25 November 2014

**State Significant Development Applications: Notice of Exhibition
Building R1 (SSD 6513), Building R7 (SSD 6623) and Building C2/C6 (SSD 6425)**

BASEMENT LEVEL 3

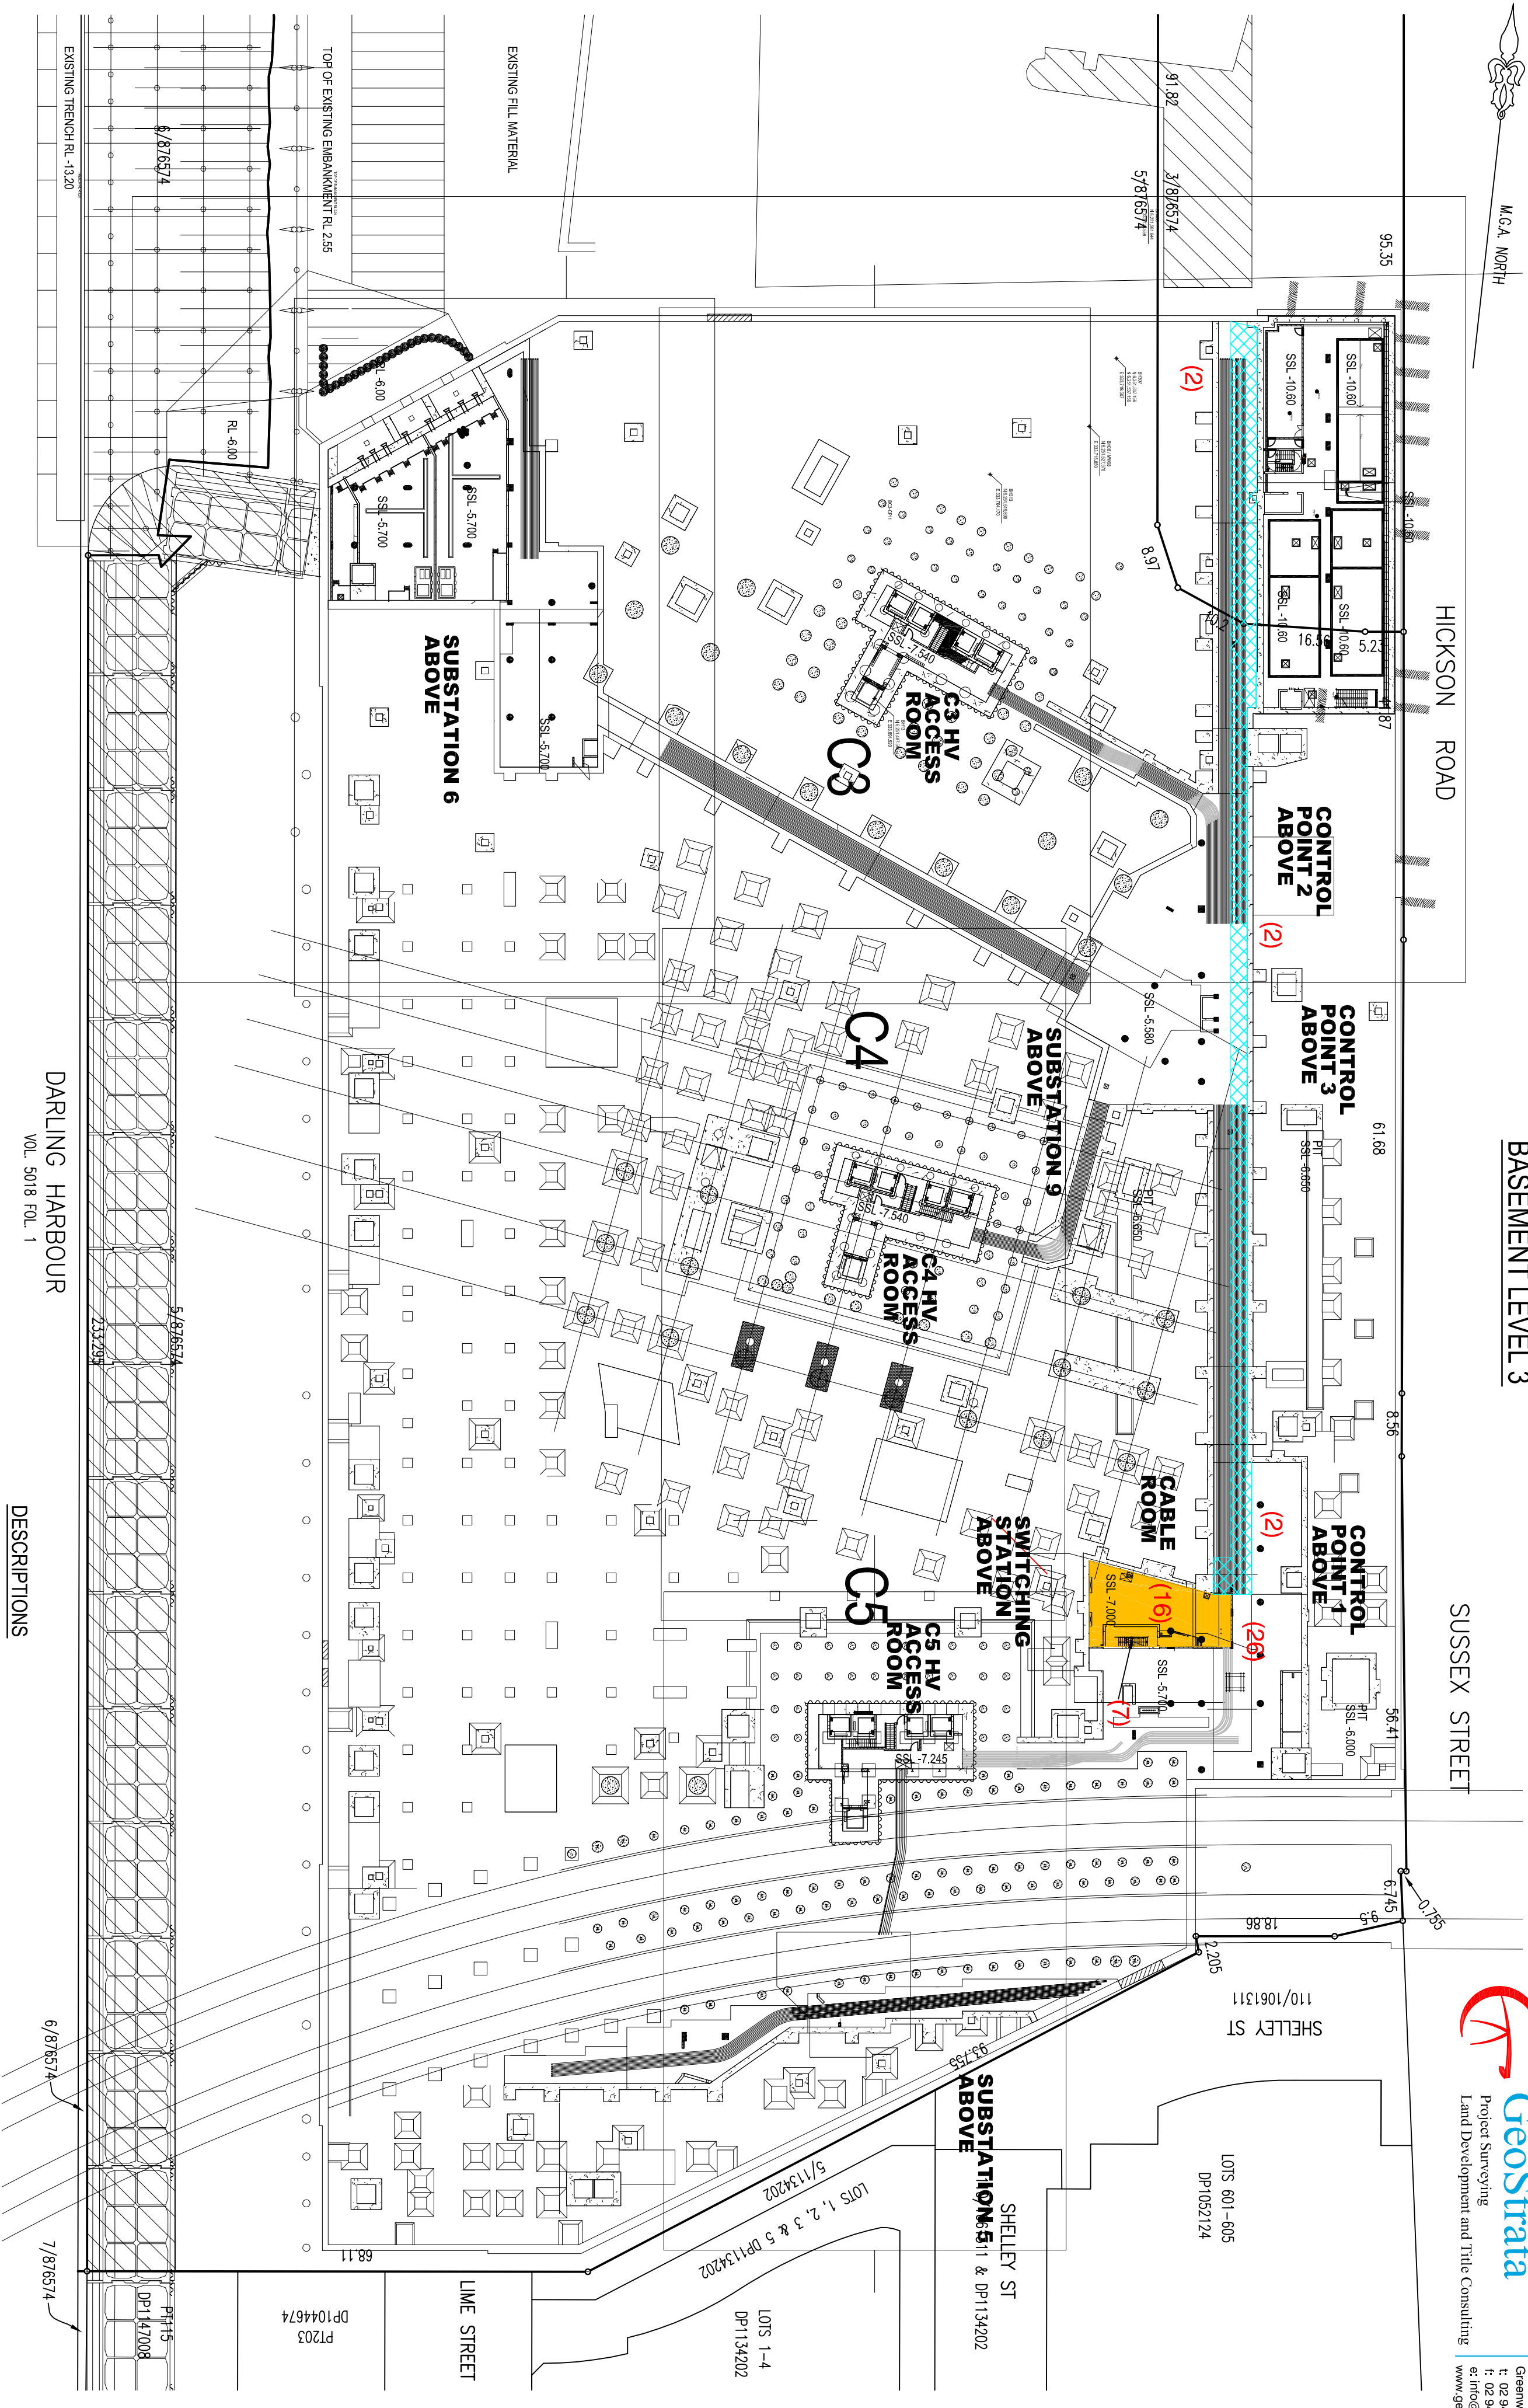
A high level review of the proposed plans for each of the developments has been undertaken and identified that the SSDs are in the vicinity of Ausgrid's future electricity infrastructure within the Barangaroo South Precinct.

1. The Proponent shall continue to negotiate with Ausgrid and finalise the following in favour of Ausgrid:
 - i. easements;
 - ii. leases; and
 - iii. rights of way,as contemplated in the enclosed plans prepared by Patrick Walsh of GeoStrata, dated 31 July 2014.
2. The Proponent shall provide reasonable access to Ausgrid for the installation and commissioning of Ausgrid's electrical infrastructure throughout the course of the project.
3. The Proponent shall not interfere with Ausgrid's electrical infrastructure.
